Ribble Valley Borough Council
Housing & Development Control

Your ref 3/2020/0602
Our ref D3.2020.0602
Date 11th May 2021

Application no: **3/2020/0602**

Address: **Holden Clough Nursery Bolton by Bowland Road Bolton by Bowland BB7 4PF**

Proposed Ground Floor Plan

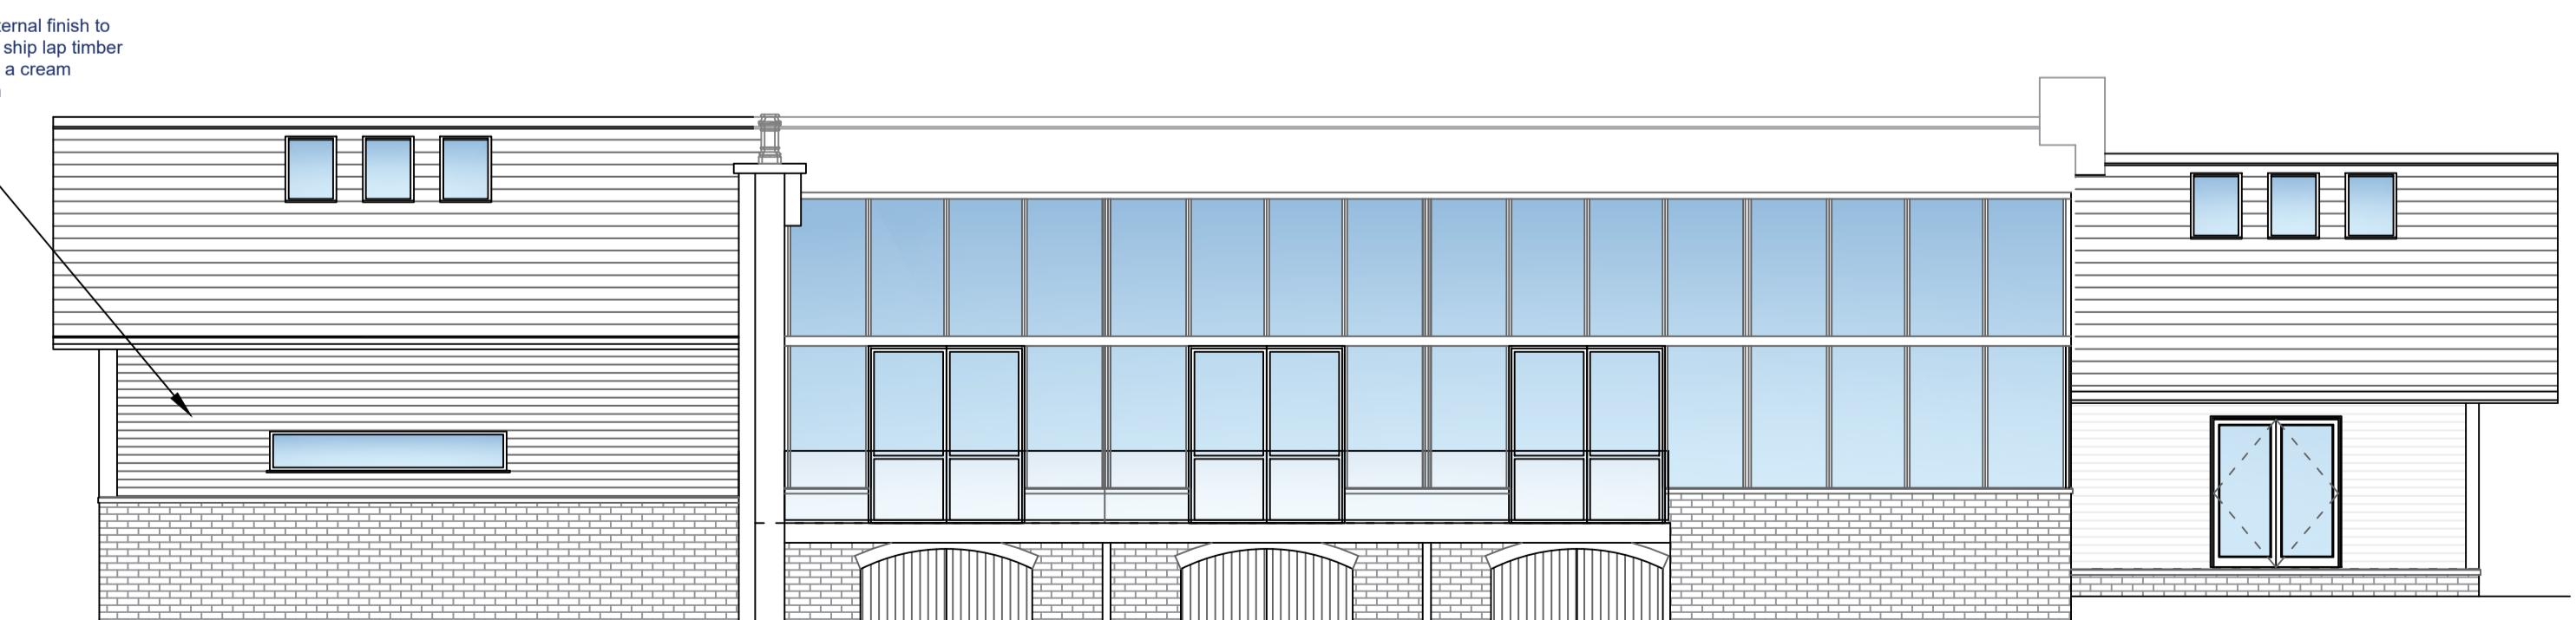
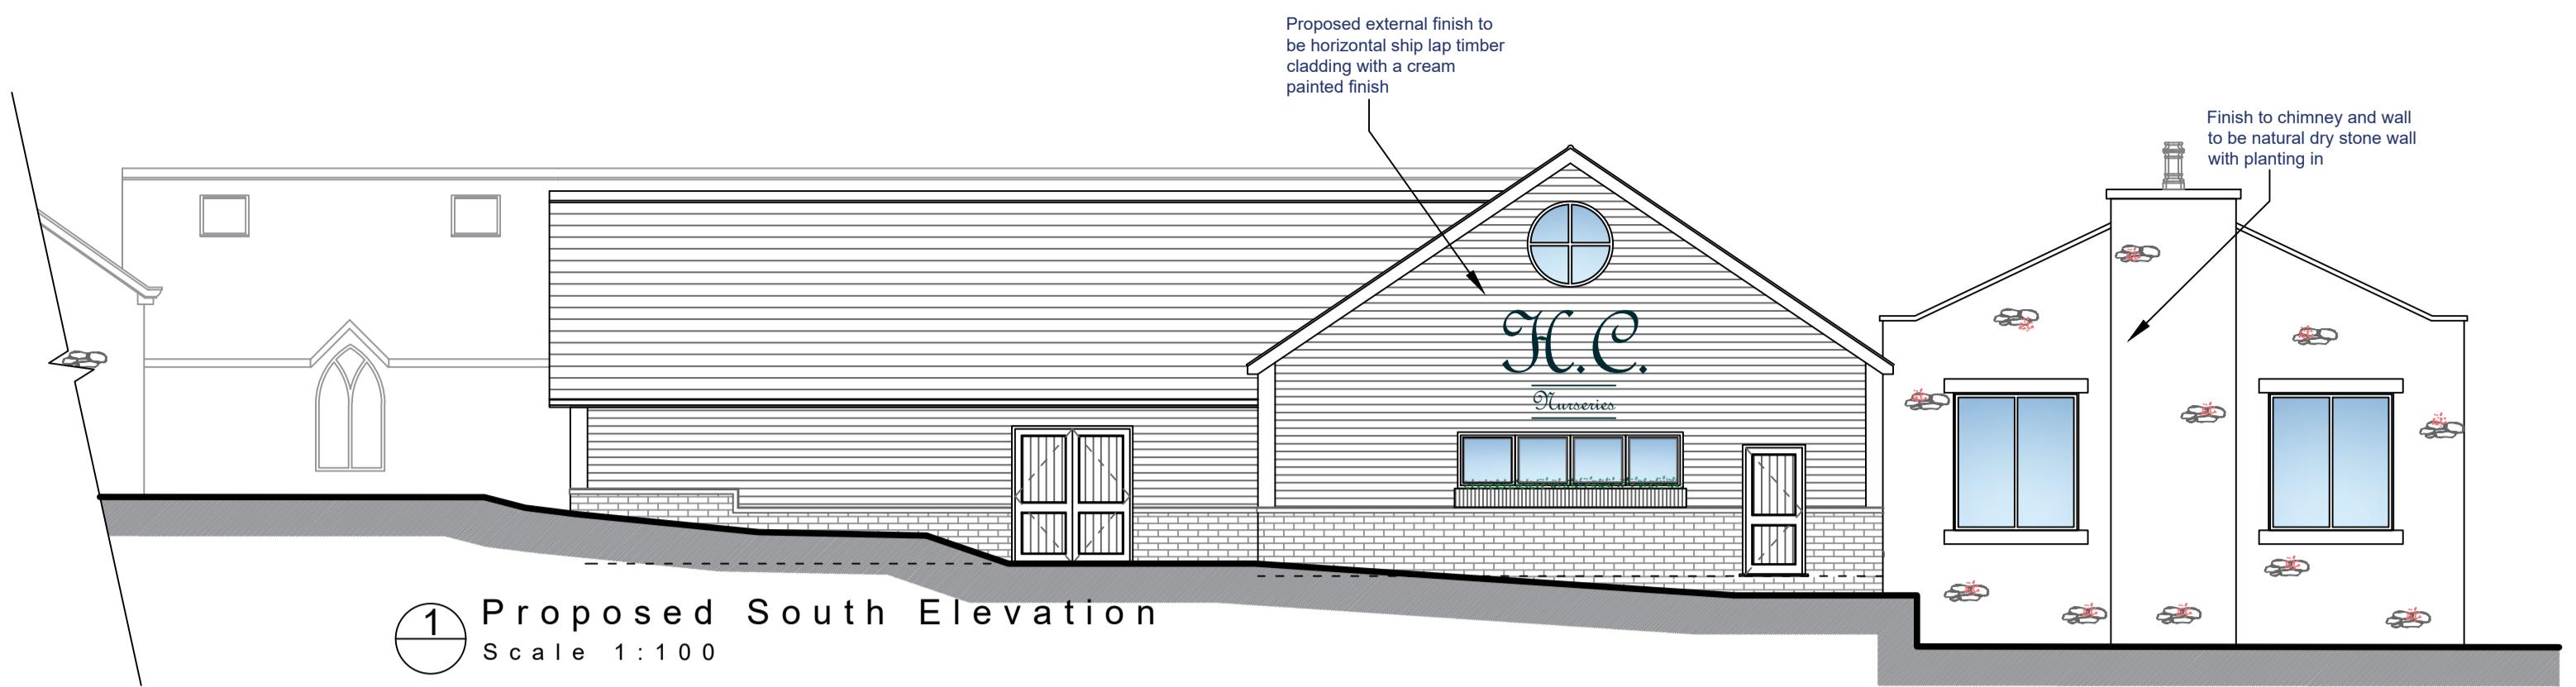
- Holden drawing number 20-01 Rev E titled "Proposed Plan."
- Supporting Information titled "Supporting information in respect of amended plans" dated 28th April 2021.

The LHA have reviewed the Application Form, which can be viewed on the LPAs website and understands that the proposal will increase the internal floor area of the current café from 426 sqm to 780 sqm.

Currently, as stated on the Application Form, the site provides 71 car parking spaces but following the proposal there will be a loss of 3 spaces leading to the site

providing 68 spaces. Notwithstanding the existing uses on the site and the proposed deli retail element, the proposed increase in the floor area will require a parking provision of 98 parking spaces. Therefore, there is a shortfall in 30 parking spaces at the site.

Despite not complying with the guidance contained in the Joint Lancashire Structure Plan, the LHA will accept the shortfall in parking at the site. This is because the site has been placed under Condition 9 of planning application 3/2018/0396, which has restricted the maximum number of covers the site can undertake per day. Currently the site provides a maximum of 140 covers per day.

As a result of the proposal not increasing the number of covers the café undertakes per day, the LHA will accept the shortfall in parking and so have no objections to the proposal.

2. Unless otherwise agreed in writing with the Local Planning Authority, the C3 use (café/restaurant) of the site, including both internal and external facilities, shall be restricted to a total of 140 covers of which only 100 shall be internal covers.
